Planning Application ref: 2021/62/92116/E

Detached Dwelling to the rear of 23 Fall Lane.

Objections:

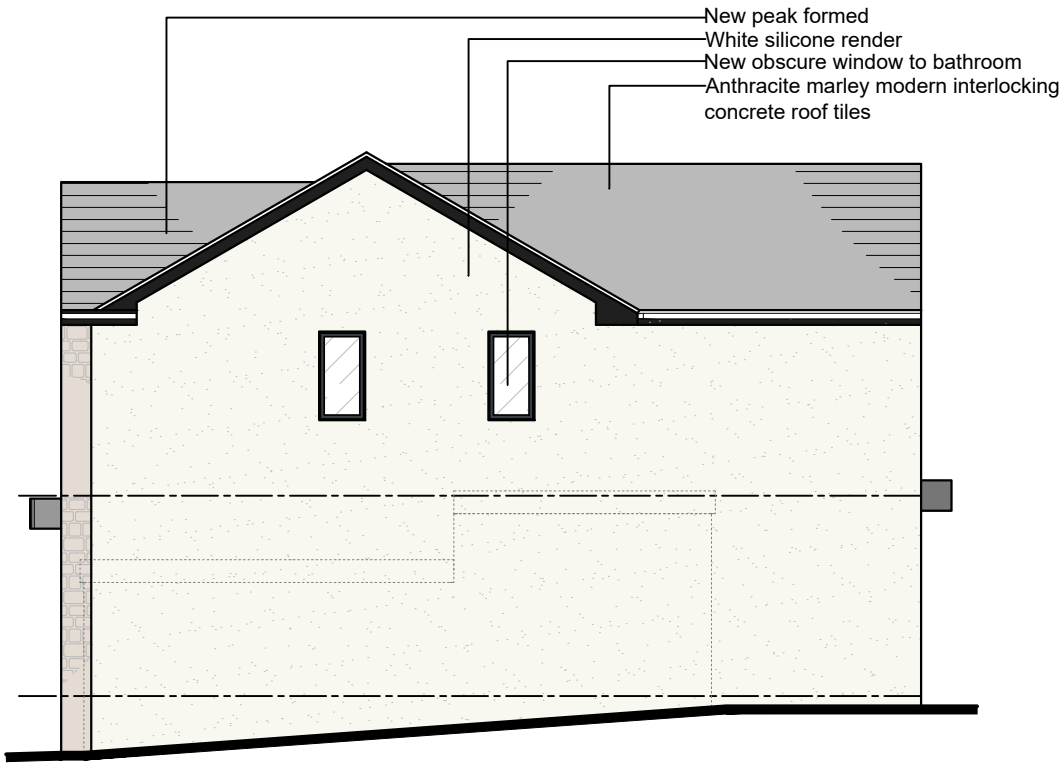
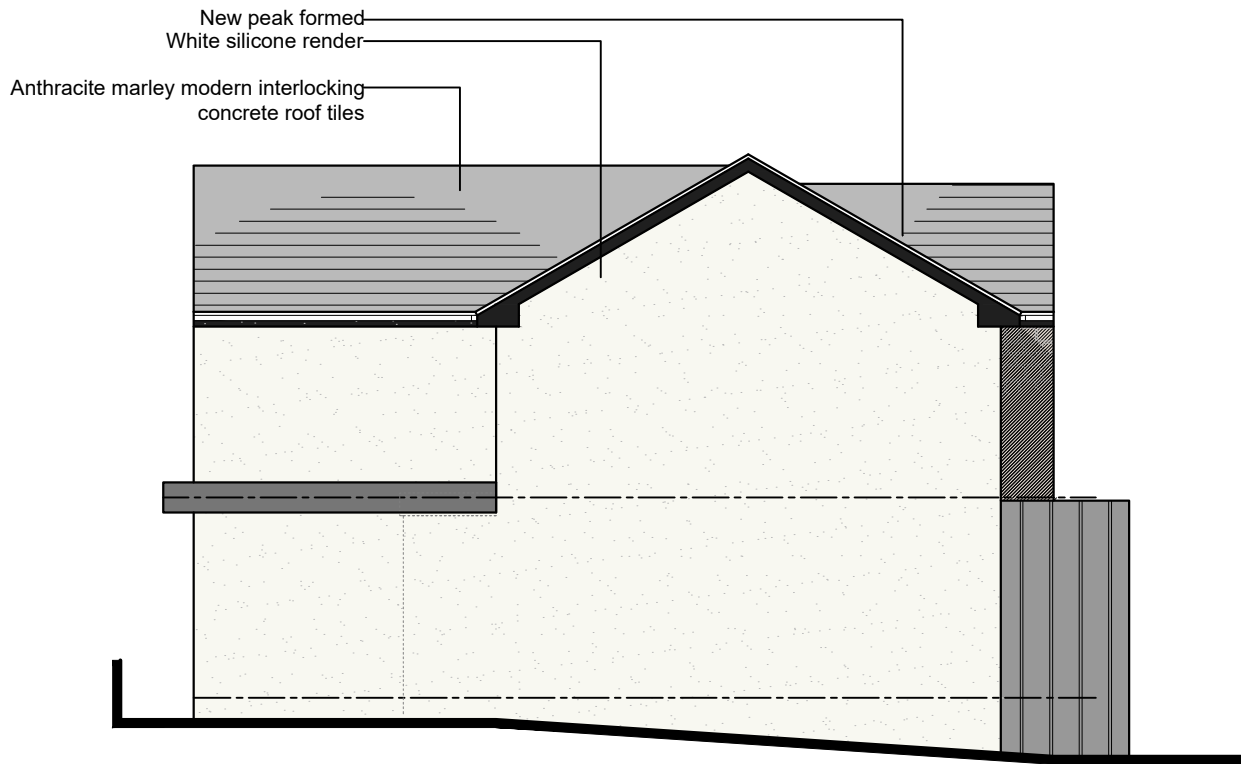
The Architects state that there is no strong character to the area in terms of appearance using mix of materials used in the local area, stone, brick, and render, I cannot see any predominantly white properties with blue roofs in the village so again the Architects appear to be wrong in their assumptions all seem to be brick, stone with traditional coloured roof tiles.

The Architects also state will “reflect the proportions of the dwelling to the rear of 27 & 29 Fall Lane” the property in question is Dorma-bungalow built of stone and black tile roof, not a 2 story with a basement to the front so really a 3-story property with white render and a blue roof.

SITE SECTION A-A

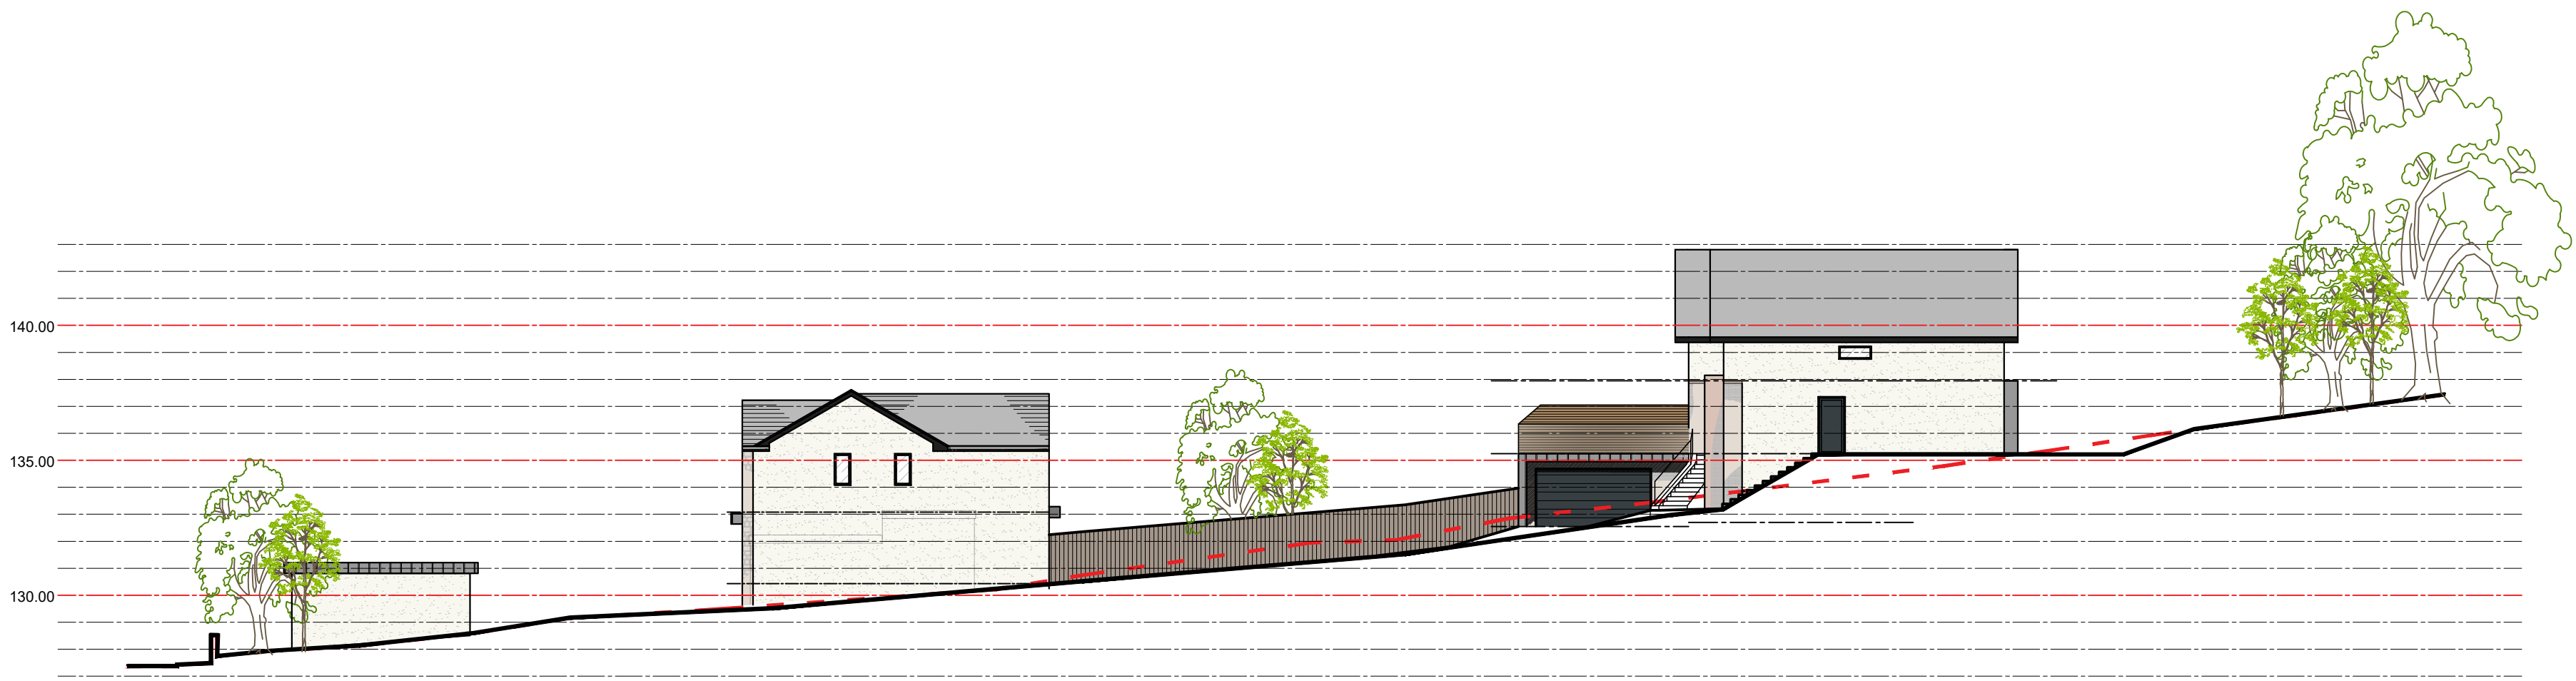
The proposed property will also overlook the children's playground in the recreational area immediately behind the proposed new property, it my understanding that recent changes to planning would prevent any new development being built which would overlook a children's play area.
